Catherine Field Primary School Mod 2 Additional Information – 19th November 2020

SECTION 4.55(1A) MODIFICATION APPLICATION, NEW CATHERINE FIELD PUBLIC PRIMARY SCHOOL (SSD 9477 – Mod 2) – ADDITIONAL INFORMATION

We refer to the Department of Planning, Infrastructure and Environment (DPIE) request for additional information dated 10th November 2020 relating to matters raised by Camden Council. The following information re-states the matters (in *italics*) and provides a response to each.

DRAWING NAME
LANDSCAPE: SITE PLANTING PLAN

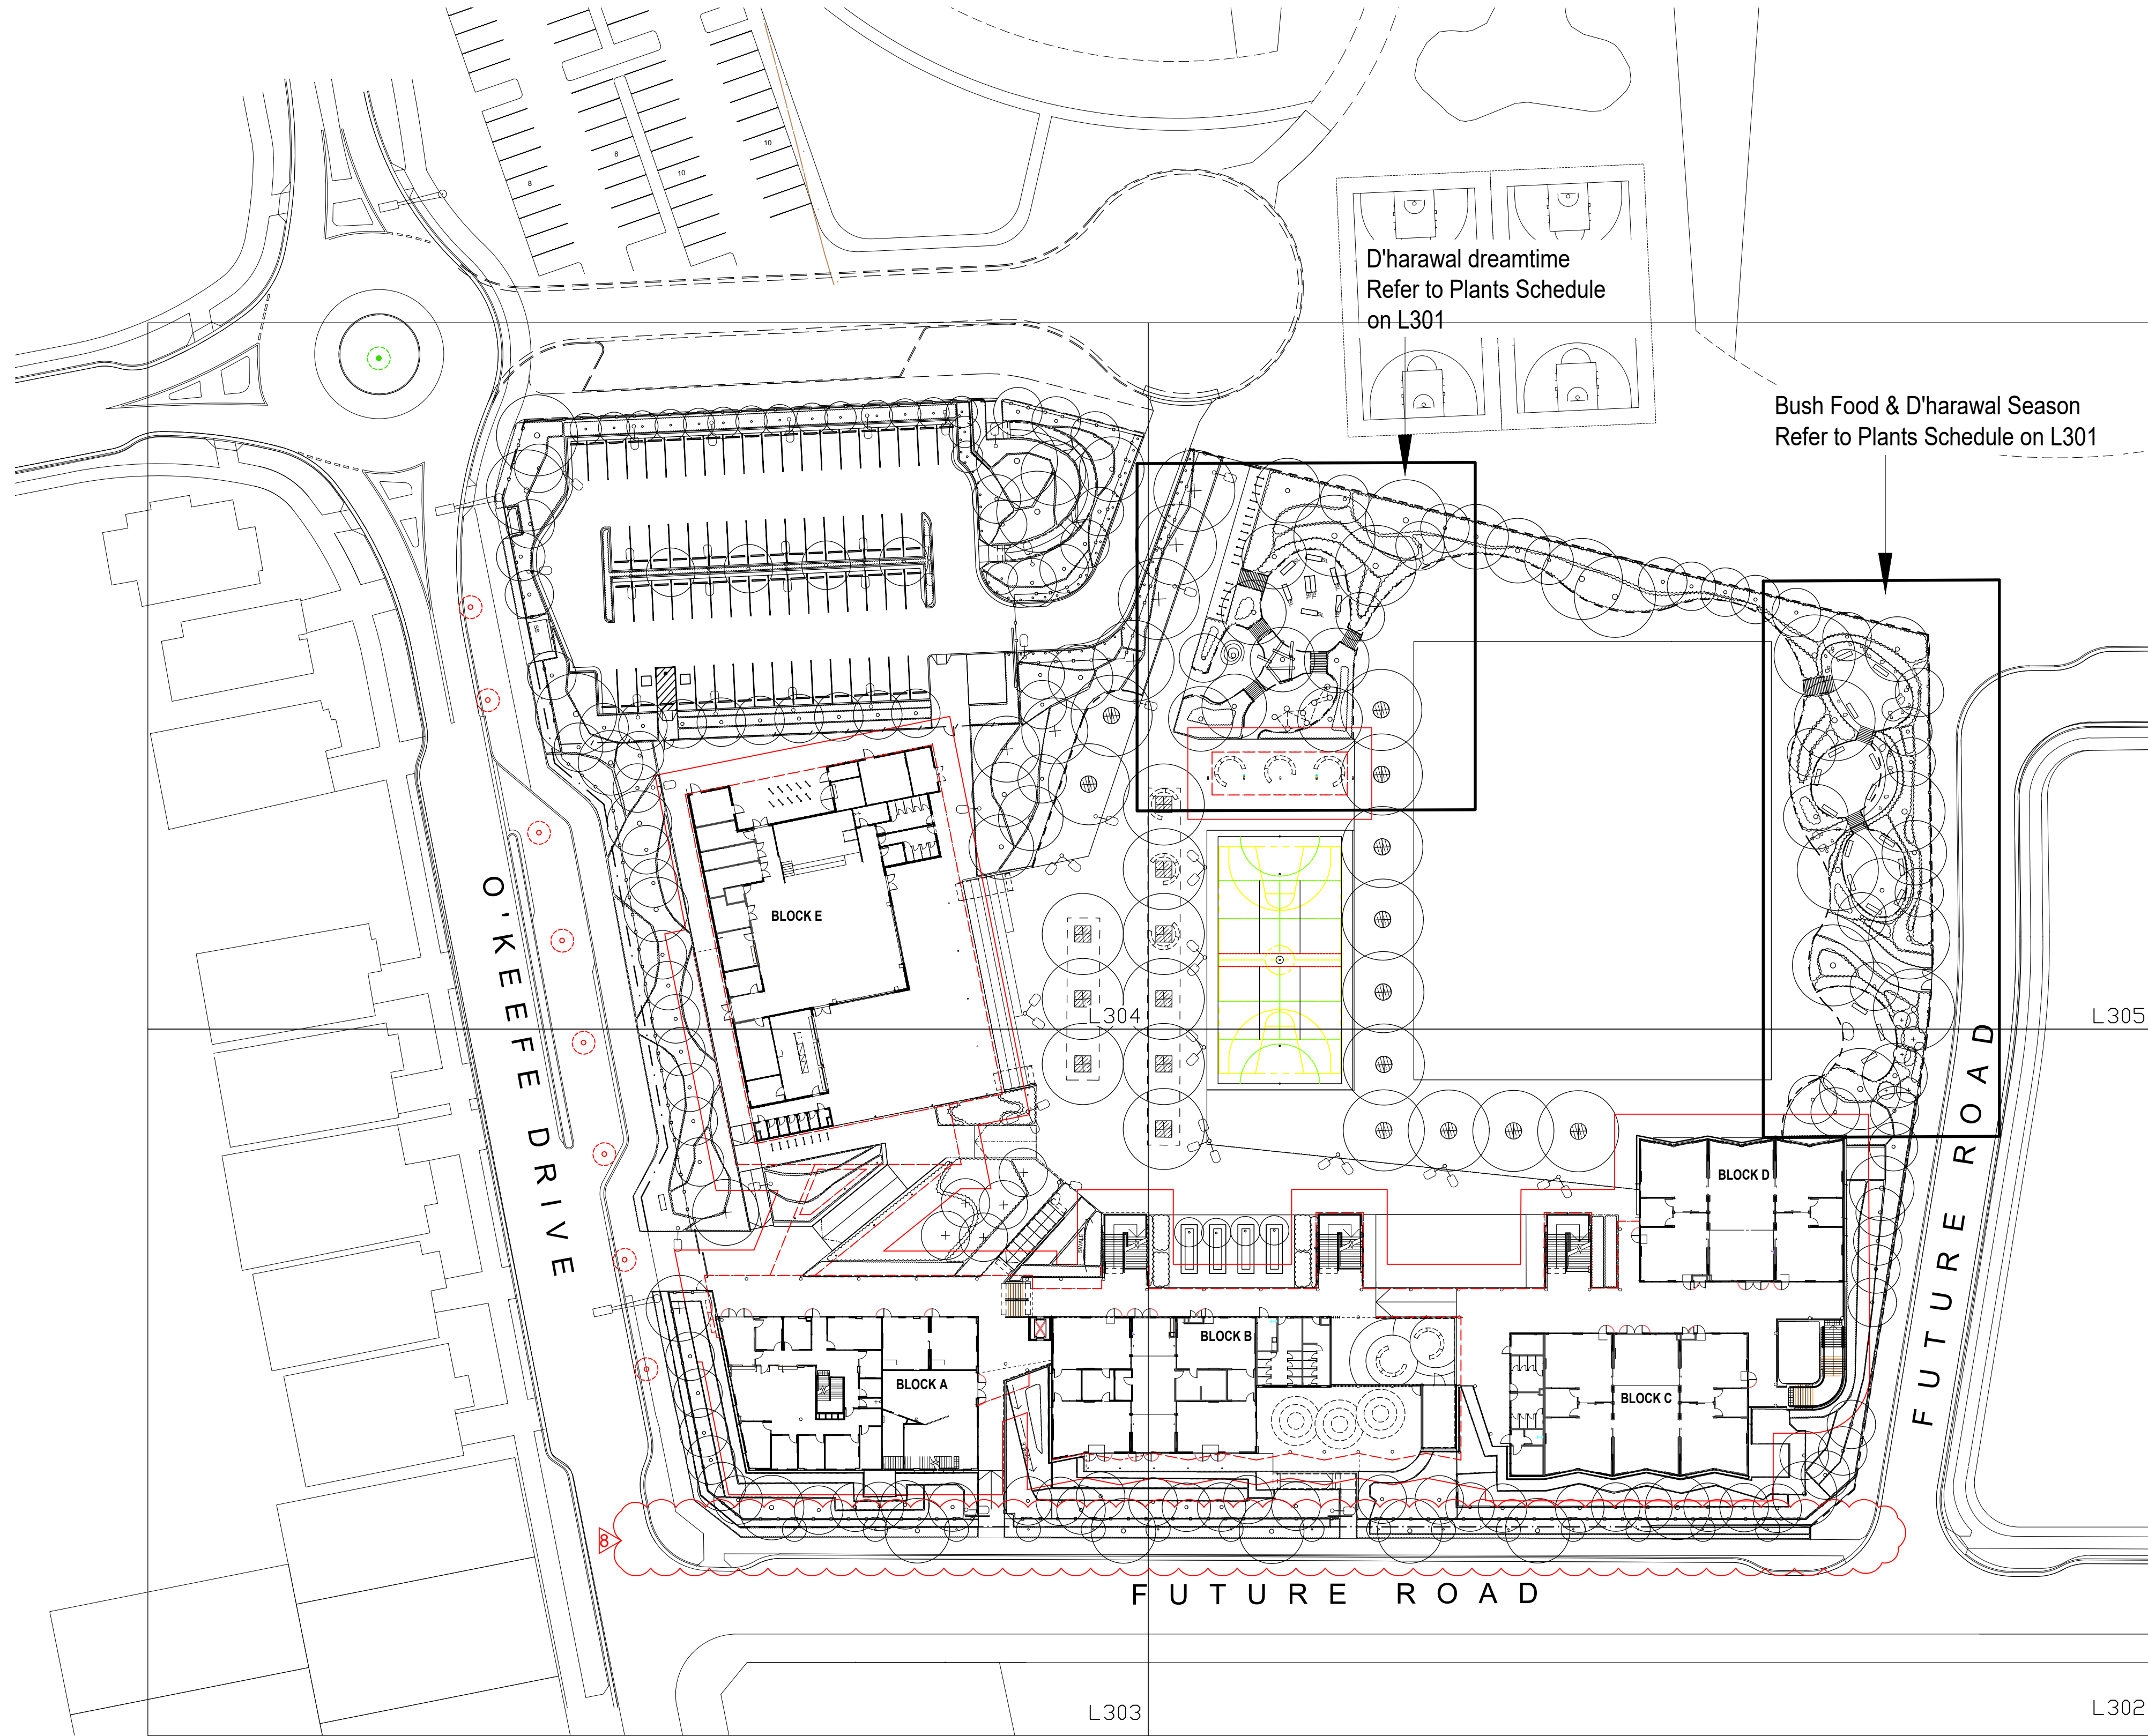
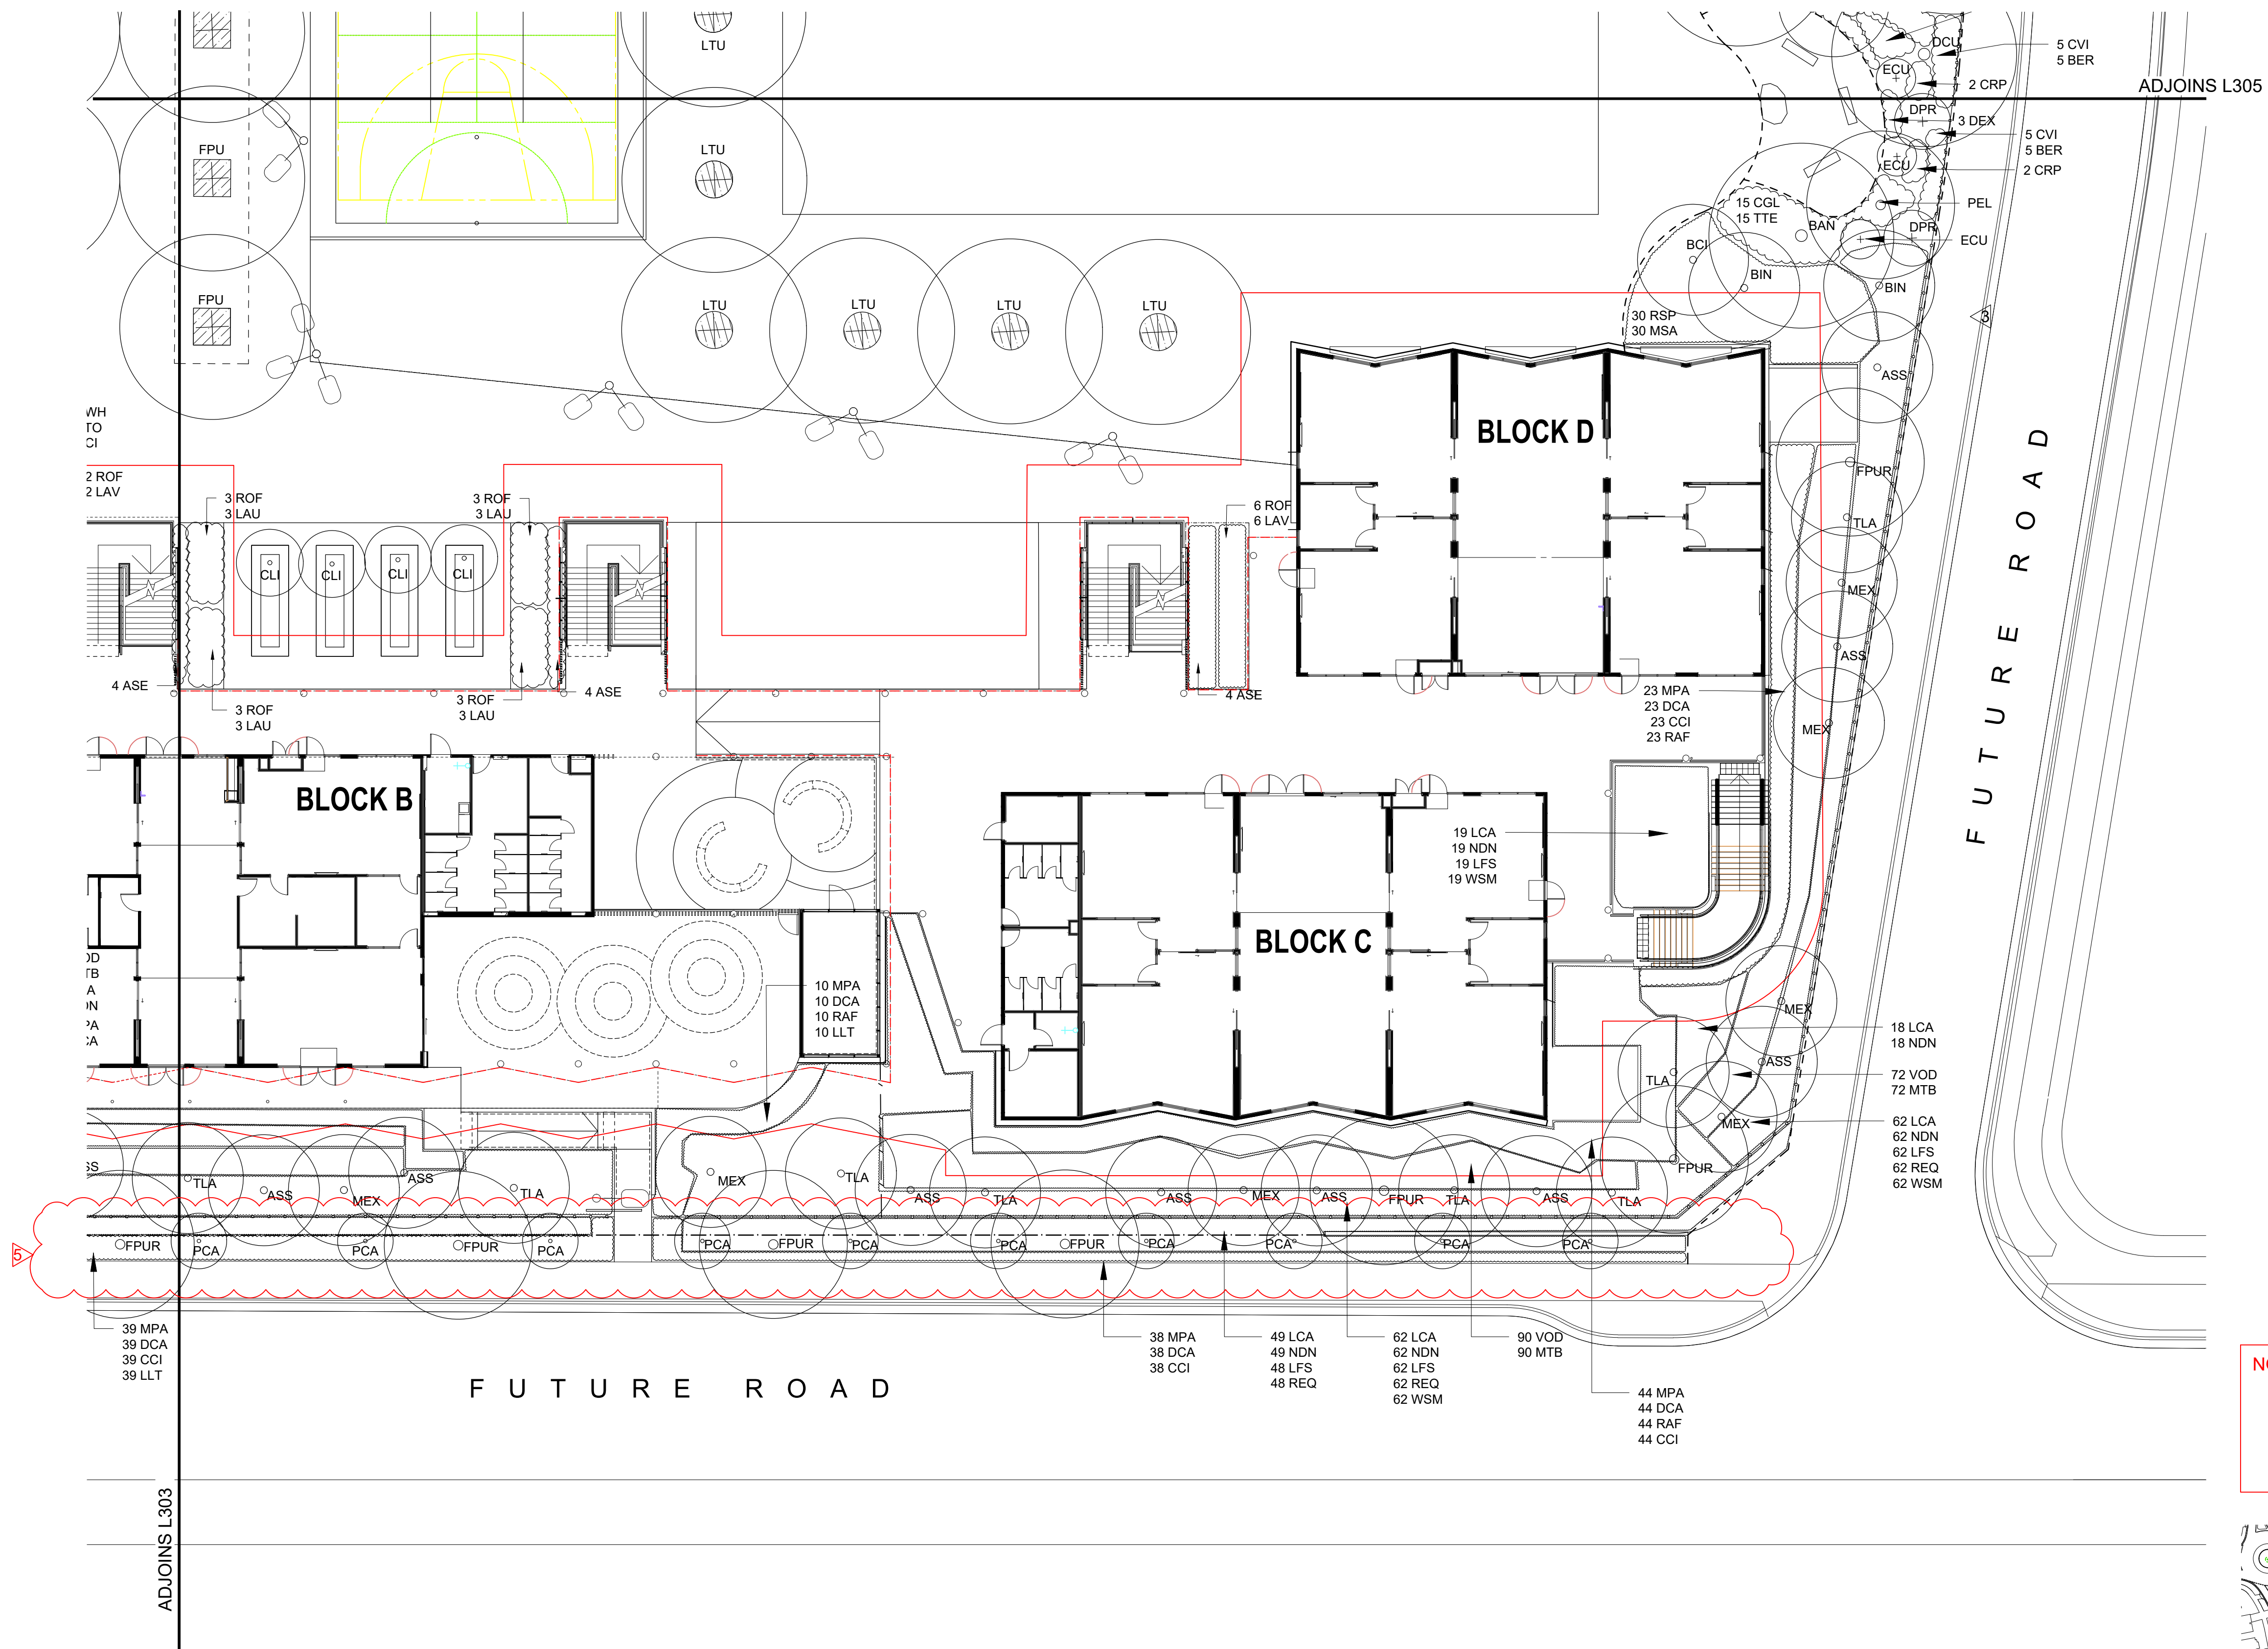
7. *The landscape plans submitted with the application show the removal of all street trees along O'Keefe Drive and no street trees along the southern perimeter road. There appears to be ample opportunity to plant street trees in the unencumbered areas of these road verges. Street trees should be avoided near the entrance and exit of the kiss and drop / interim car park to avoid blocking sight lines.*

As mentioned on page 1 street trees will not be planted either side of the connection point of the temporary access with the bus and special needs student drop off area. The depth of the bus and special needs student drop off area and the Council request for 3.5m wide footpaths in the area eliminates the ability to provide street trees in this location. Mass planting will occur within the school site including along the fence line of O'Keefe Drive. It is also noted that once the interim access is removed two street trees could be reinstated at the northern end of O'Keefe Drive.

Street trees are nominated within the southern perimeter road. Consultation with neighbouring developers and Council representatives has occurred and included consideration of required footpath widths. Updated landscape drawings are provided in **Appendix B**.
